From: Andrew Wood
Sent: 02 April 2019 10:25
To: Planning Scanning
Subject: FW: FG/220/18
Attachments: IMG_20190325_100113.jpg; IMG_20190325_100047 (1).jpg

From: [REDACTED]
To: [REDACTED] <>
Sent: Monday, 25 March 2019, 13:54:25 GMT
Subject: FG/220/18

The latest report on this application states that there will be no change to the pond area and resubmitted plans show a clear area all round the pond.

EXISTING POND ACCESS
PLAN

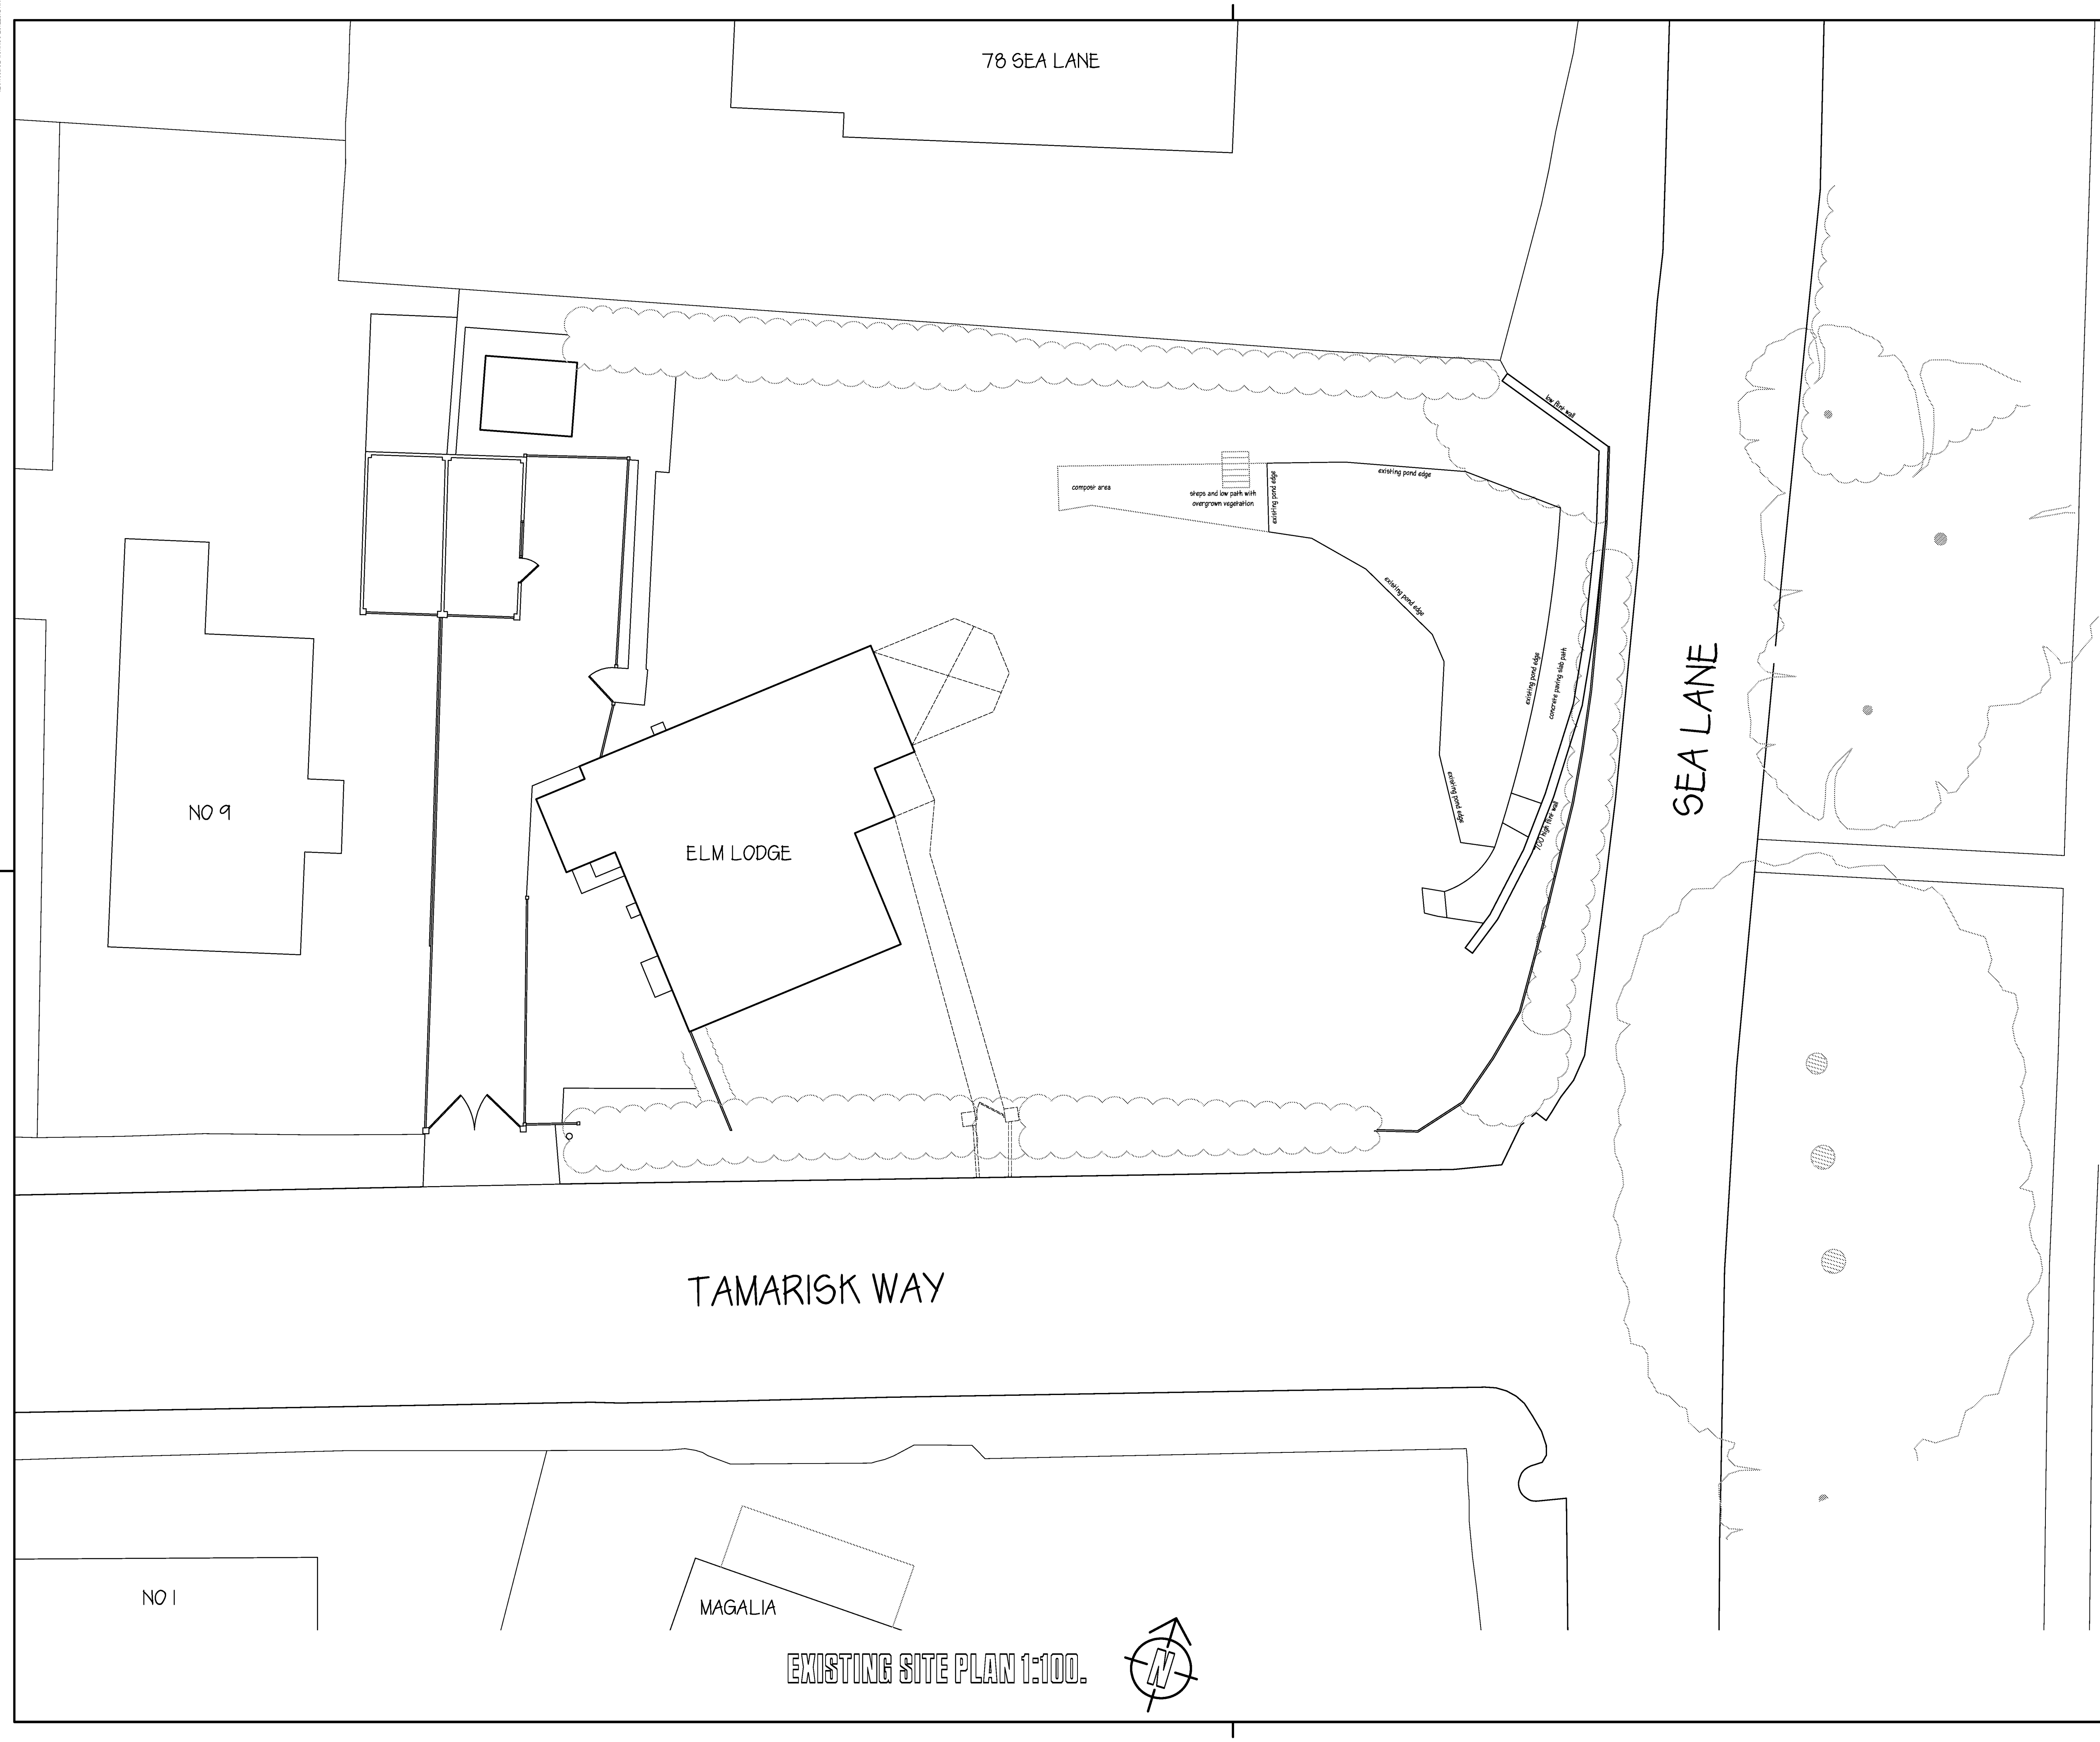
However, the pond area extends fully to the boundary wall on the NE corner of the plot, allowing no easement(ref Laura Gibbons report). The extent of the pond is clearly illustrated in the attached photos and on the land registry document already submitted. This further suggests that notwithstanding small adjustments to the siting of the new building, there is no alleviation to the threat to the drainage system.

EXISTING SITE PLAN

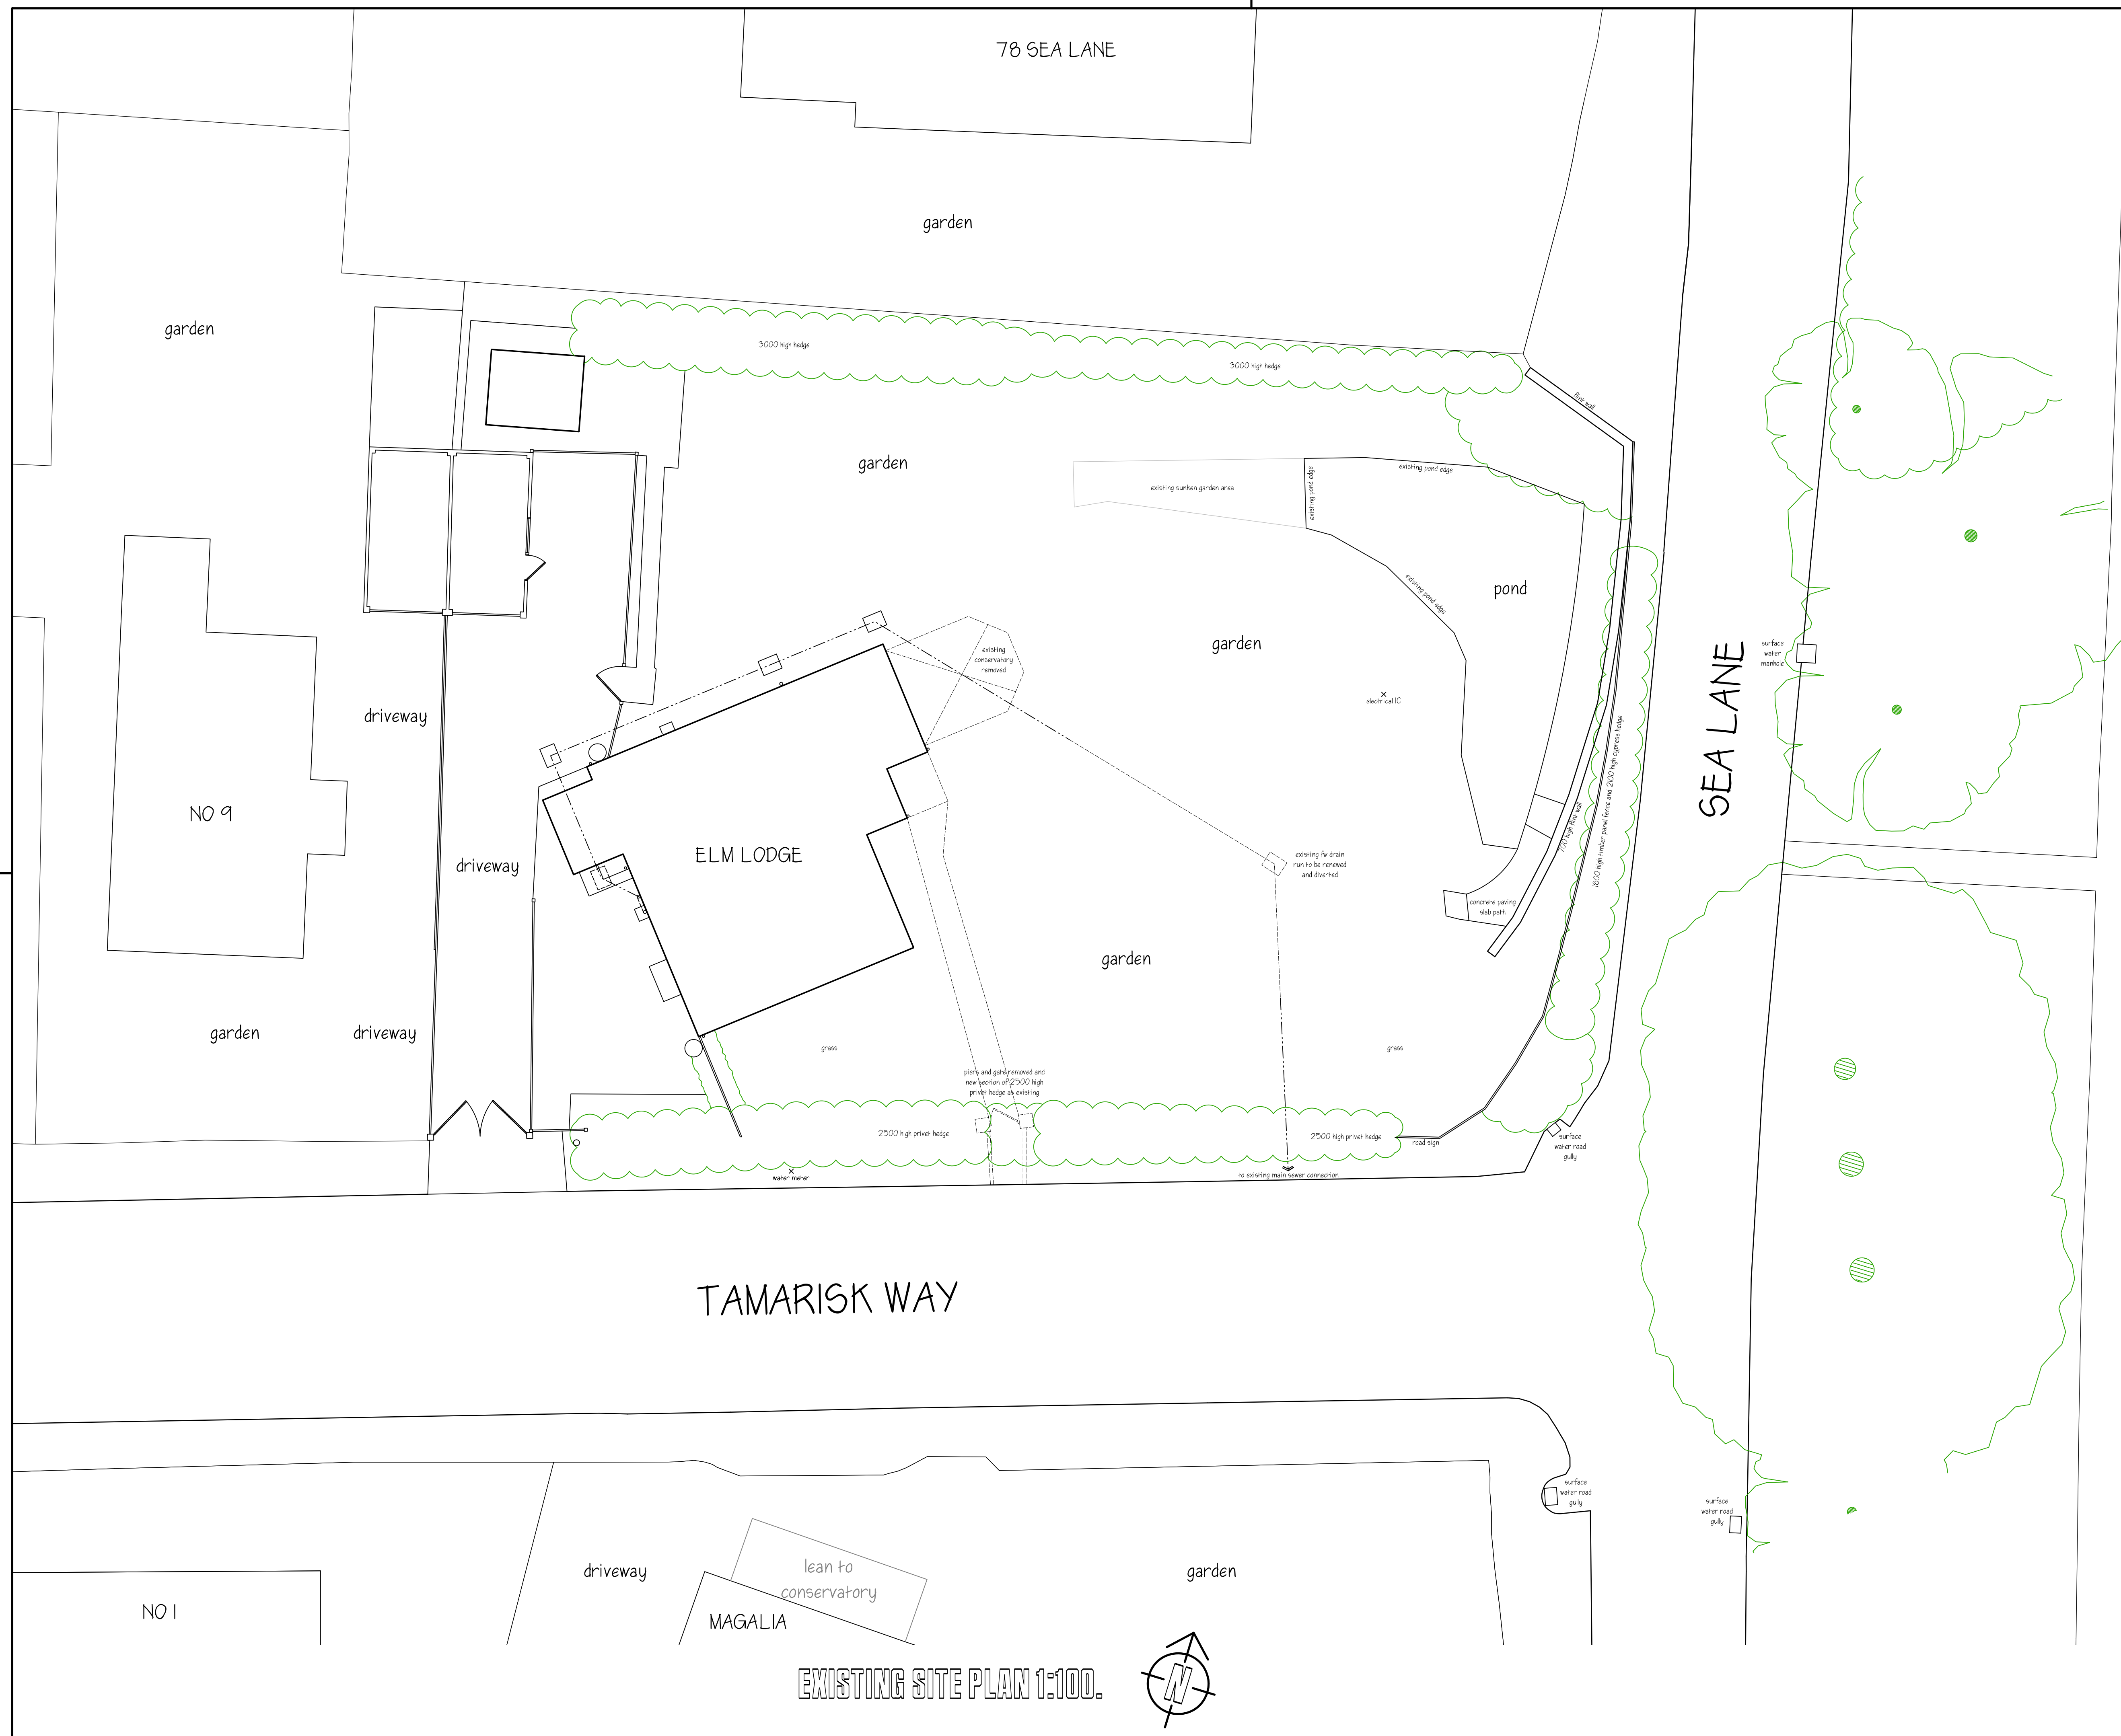
We would suggest that this, combined with the large size of the pond, severely restricts the amount of land available to build on.
